**Albuquerque
Metropolitan
Arroyo
Flood
Control
Authority**

April 8, 2015

Re: Juan Tabo Hills Estates Onsite Drainage Analysis Report, Volume 1 of 4
Engineer's Stamp Dated 8/20/14

CITY OF ALBUQUERQUE PUBLIC WORKS DEPARTMENT	
TITLE: JUAN TABO HILLS ESTATES GRADING & DRAINAGE PLAN POND DETAIL	
DESIGN REVIEW COMMITTEE	CITY ENGINEER APPROVAL
MO/DAY/YR.	MO/DY.
CITY PROJECT NO.	ZONE MAP NO.
	M-21-2
	SHEET
	5
	01

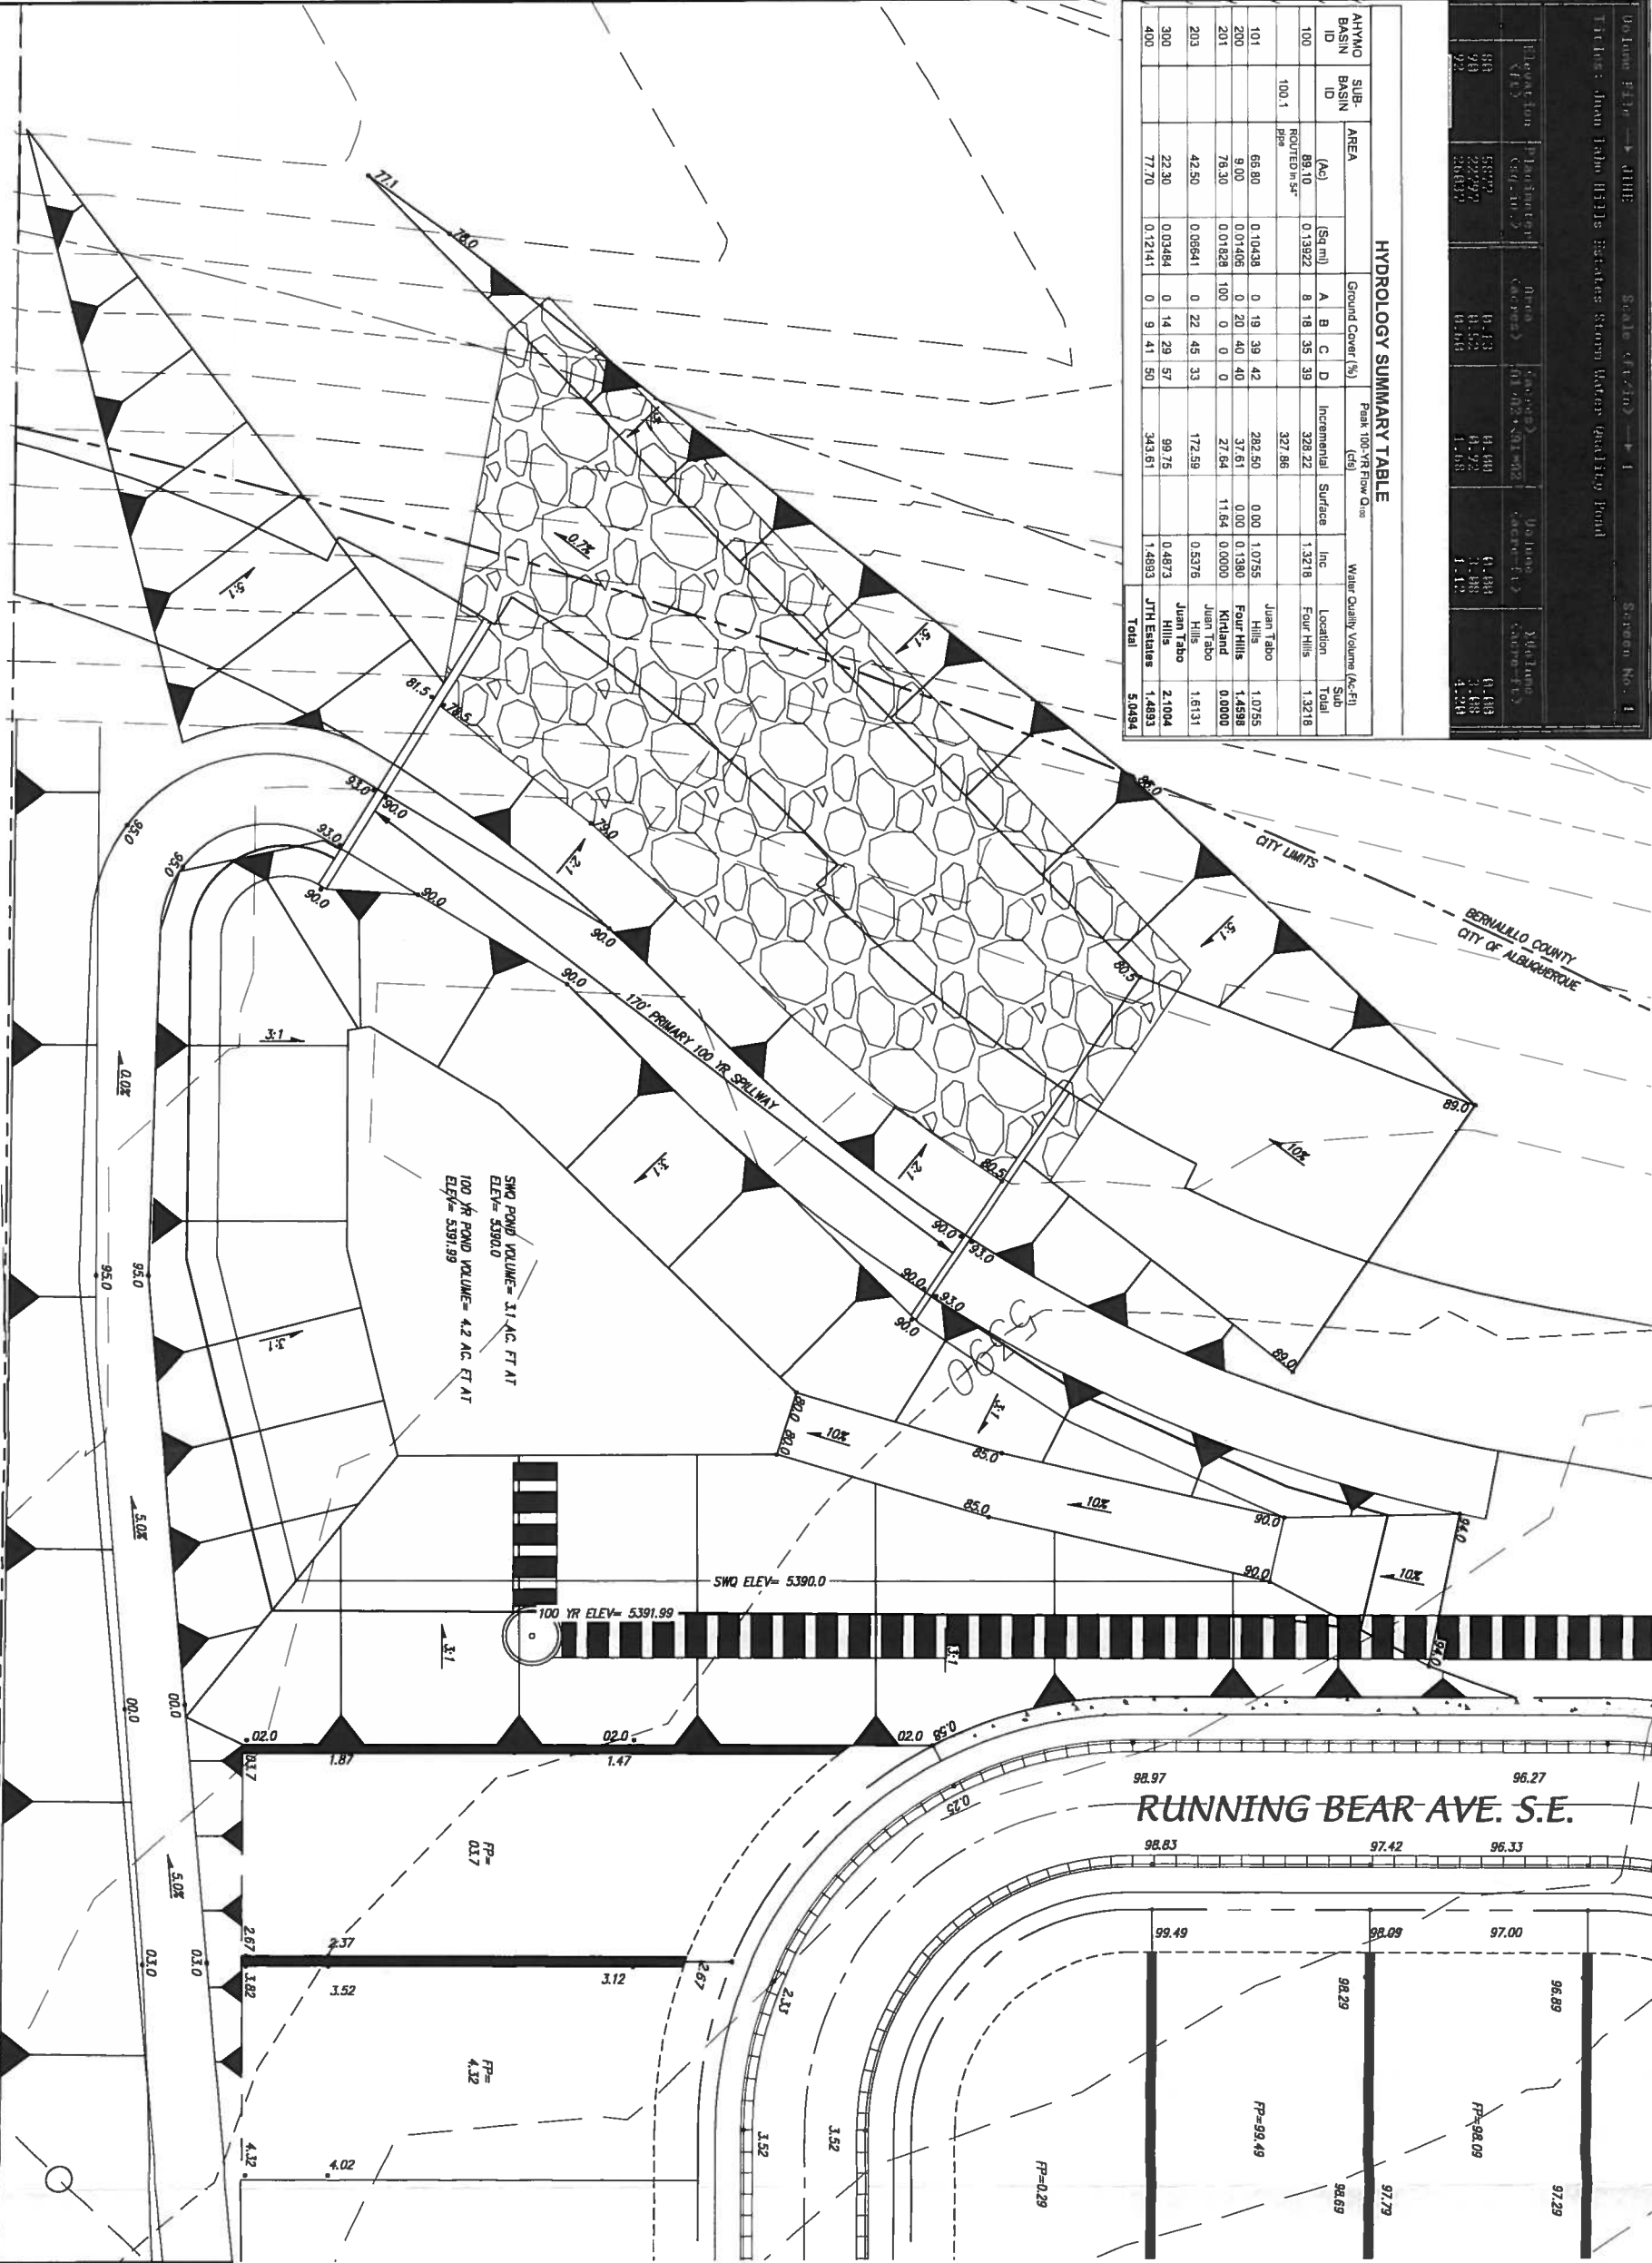
1. The storm drain into the stormwater quality pond should be at an angle much greater than 90 degrees to provide a smooth hydraulic transition. The outfall should have riprap to mitigate erosion and headcutting on the pipe. Will the City maintain the pond?
2. Some design elements of the stormwater quality pond will need to be revised. There is nothing to keep floatable debris from spilling over into the arroyo. It should have a pipe outfall to the arroyo with a ported riser or similar debris-catching device in the pond.
3. Since the bank protection will be shotcrete, the overflow weir and spillway should also be shotcrete and tie into the bank protection with a riprap dissipator bowl at the bottom of the arroyo.

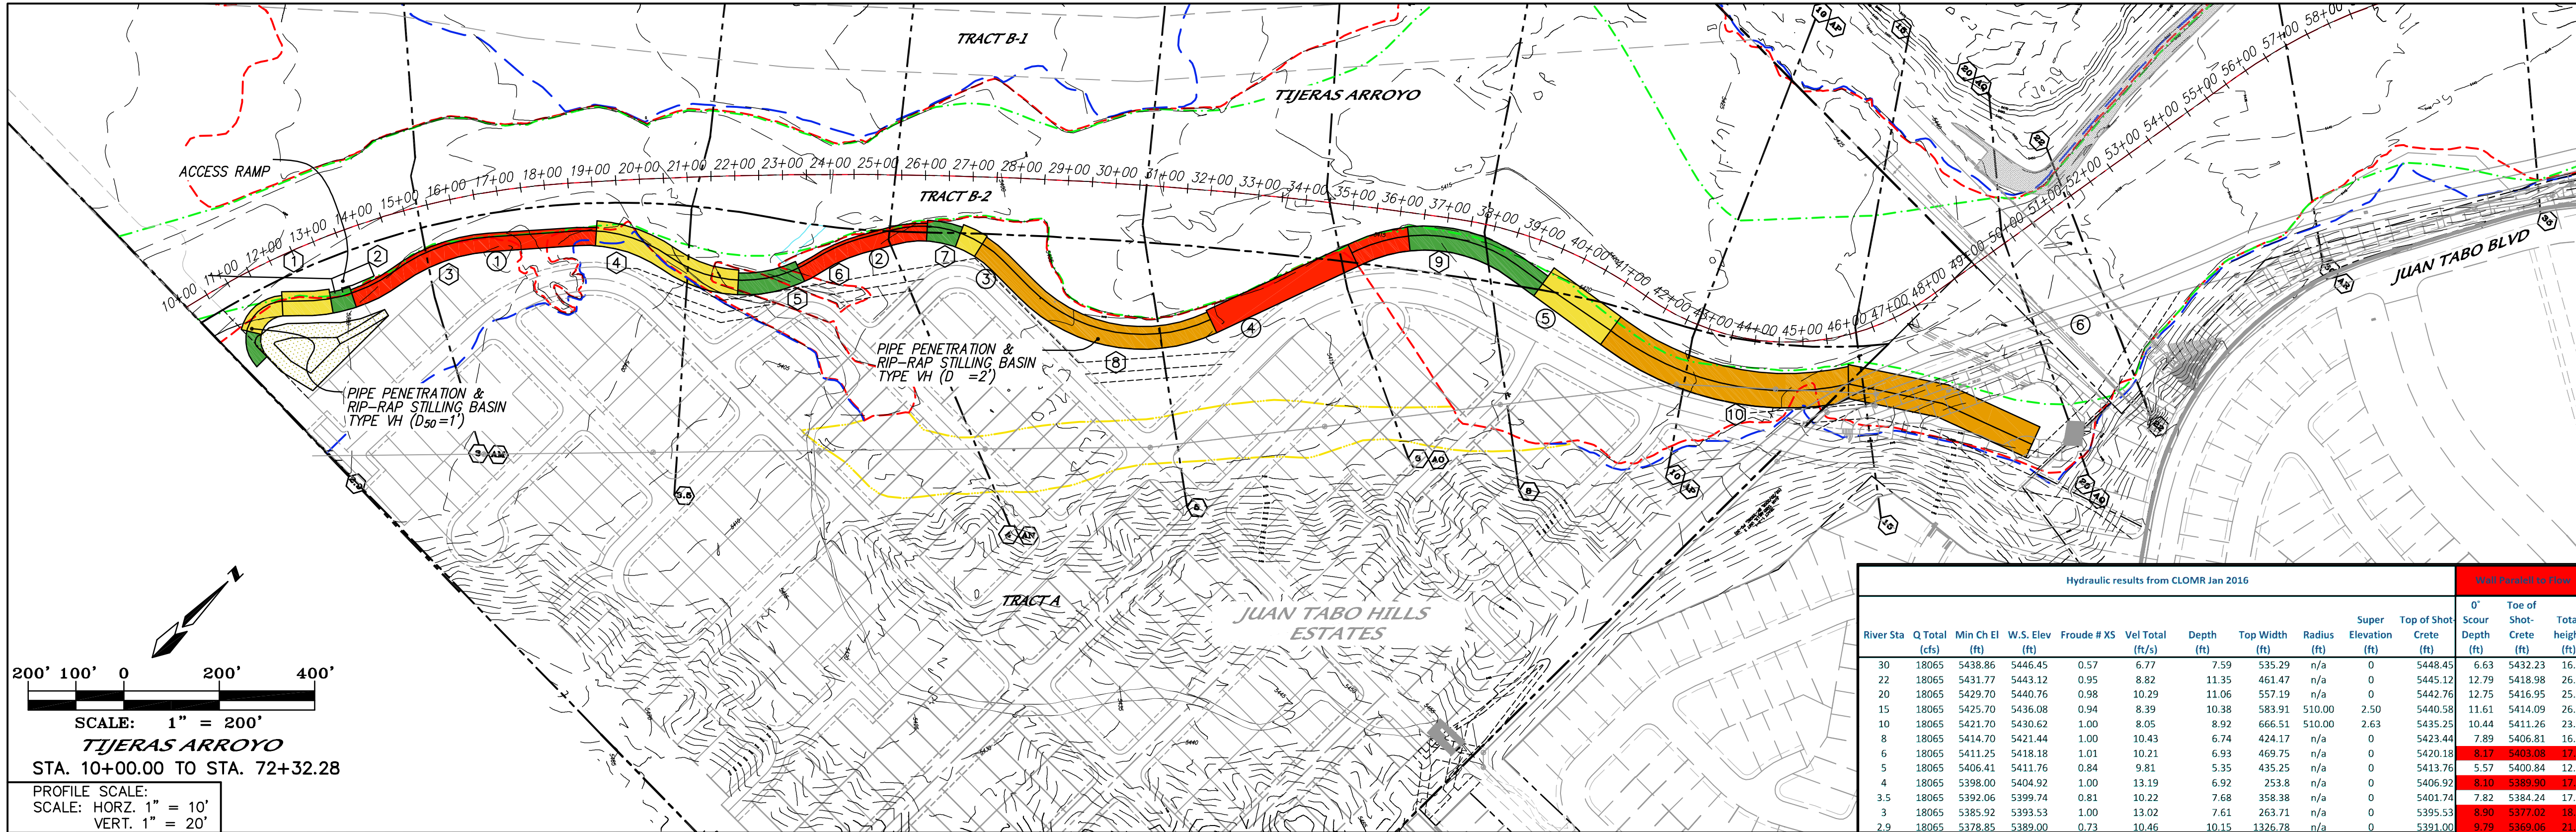
1. The AMAFCA Board of Directors commented at the October 25, 2012 meeting that drainage impacts on adjacent properties must be considered. Results of hydraulic analyses of existing and proposed conditions must be compared to ensure that increased flow rates and velocities in the Tijeras Arroyo will not cause damage and excessive, long-term erosion. AMAFCA is aware of existing erosion problems on Kirtland Air Force Base that are endangering their crossing structures and other facilities.

2. AMAFCA has a prudent line study of the Tijeras Arroyo on its project schedule. The starting date is pending. Lacking a document to specify an equilibrium slope and locations of future grade control structures, you should calculate the existing potential equilibrium slope from the Juan Tabo bridge to the Wyoming bridge. (This will be a straight grade calculation. Compare it to the 1.25% equilibrium slope from the 1990 DMP). The elevation should be compared to the local scour, and bank protection should extend to the greater depth of the two.
3. The upstream end of the bank protection must tie into something.
4. AMAFCA will need an access road to the bottom of the arroyo.
